1/02/2022

WST22/00004/01 | SF2022/013705

SSD-5012 MOD 2 – PROPOSED EXTRACTIVE INDUSTRY – ATLAS-CAMPASPE MINERAL SANDS, BALRANALD – WORKFORCE SHUTTLE BUS

Figure 2a

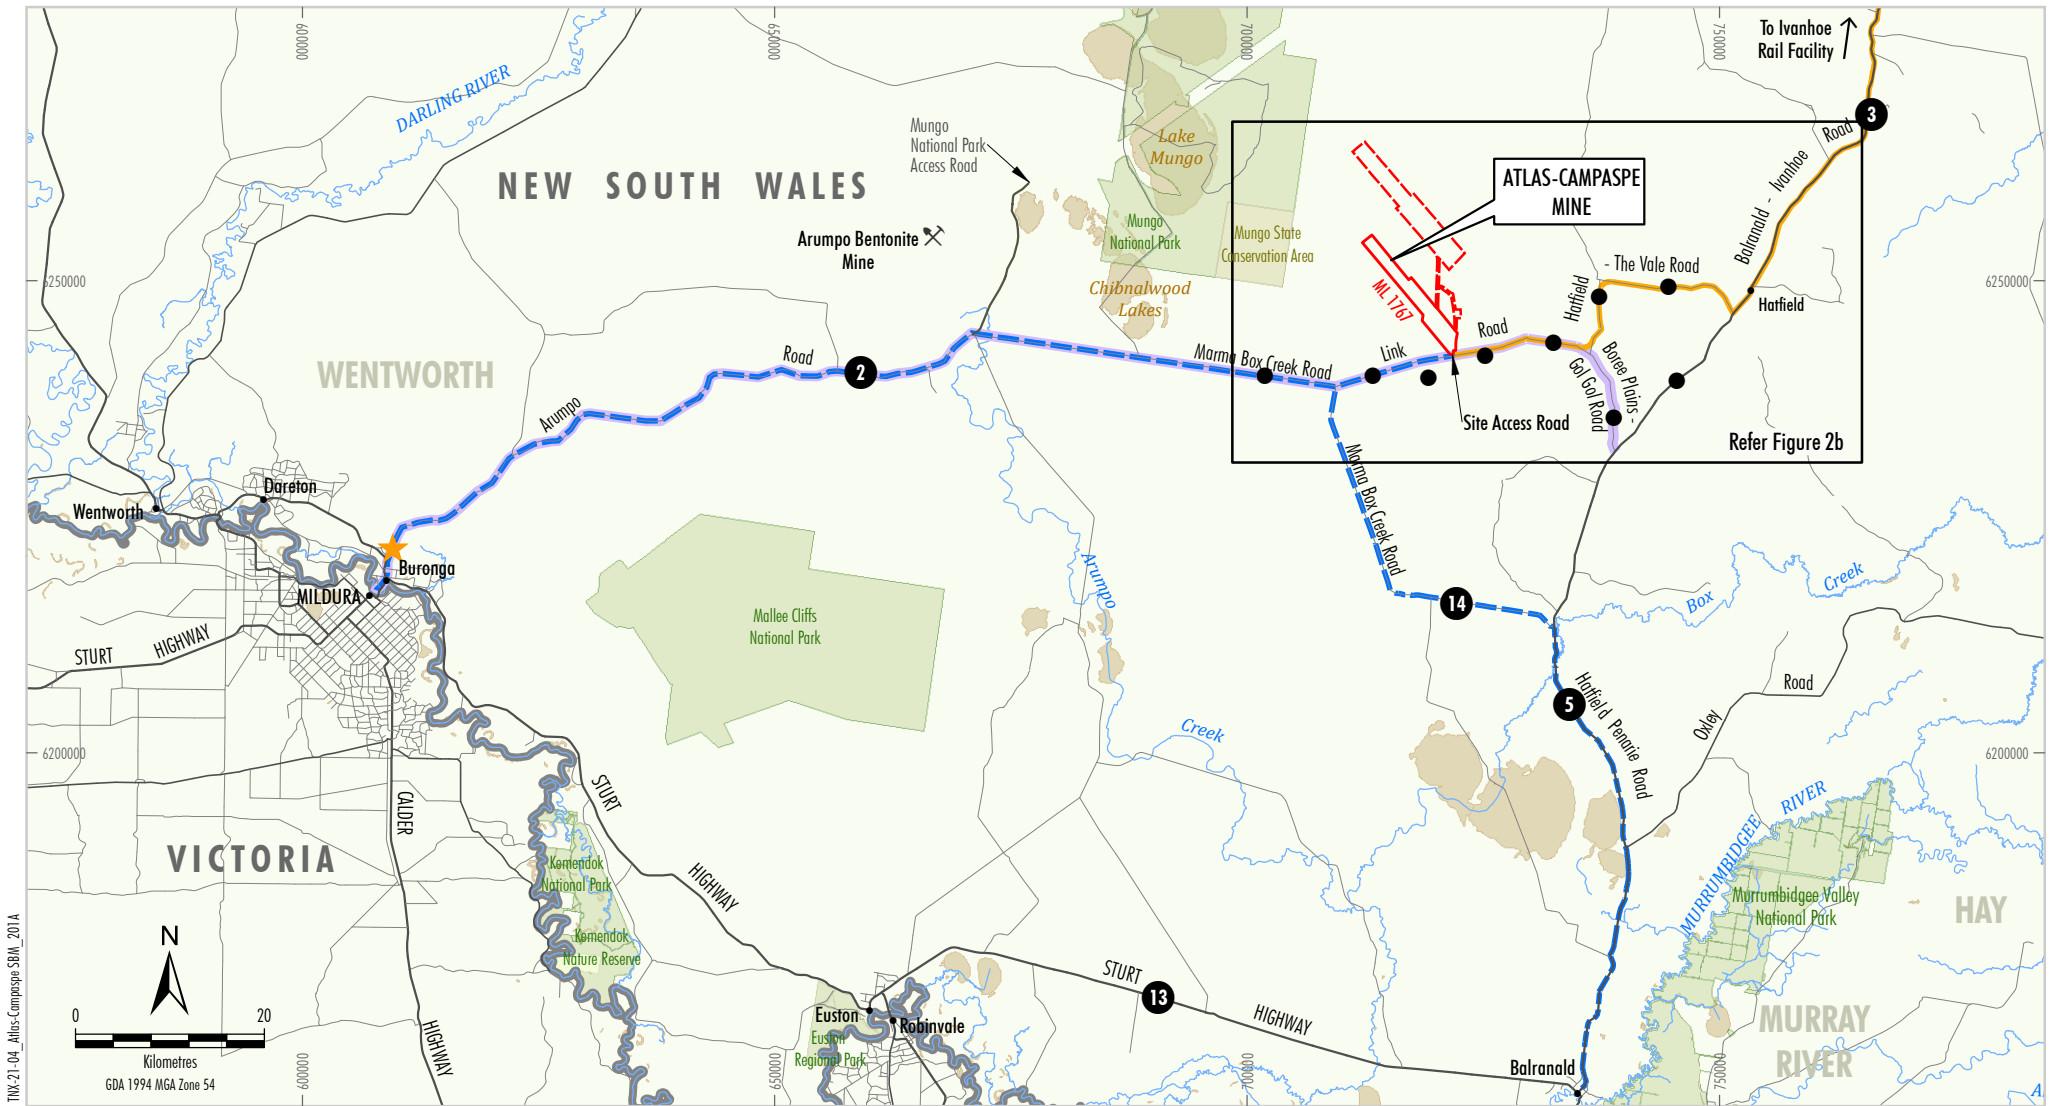
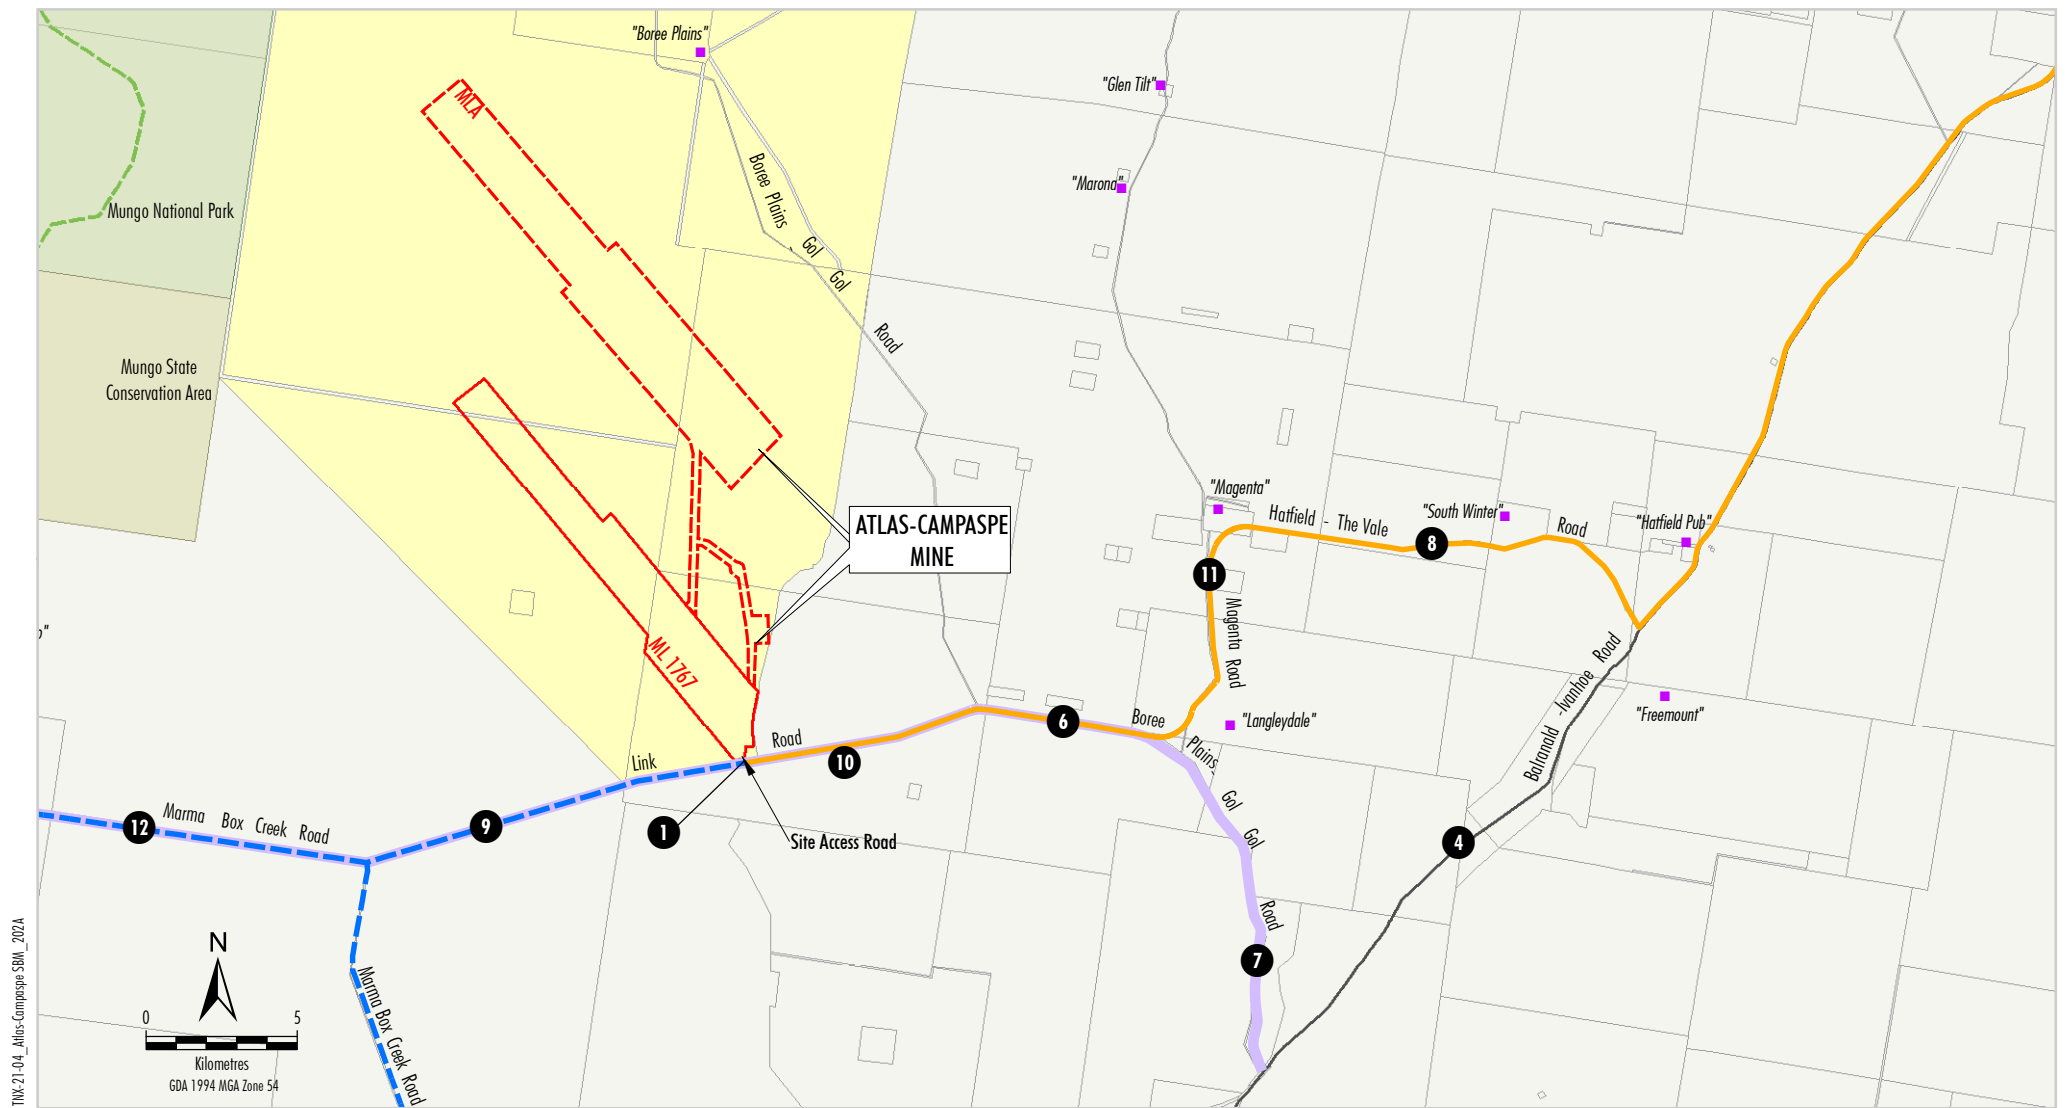
- Table 3 in the Modification Report suggests shuttle buses would use Ivanhoe-Balranald Road (between Boree Plains – Gol Gol Road and Sturt Highway) however the proposed shuttle bus route shown in Appendix 2 does not propose shuttle bus use within this section. Clarification is required.
- The Traffic Management Plan must be amended following any changes to the development consent.
- Appendix 3 and 3A are required to be amended to identify the light vehicle access route proposed as a part of this modification if the modification is approved by the consent authority.
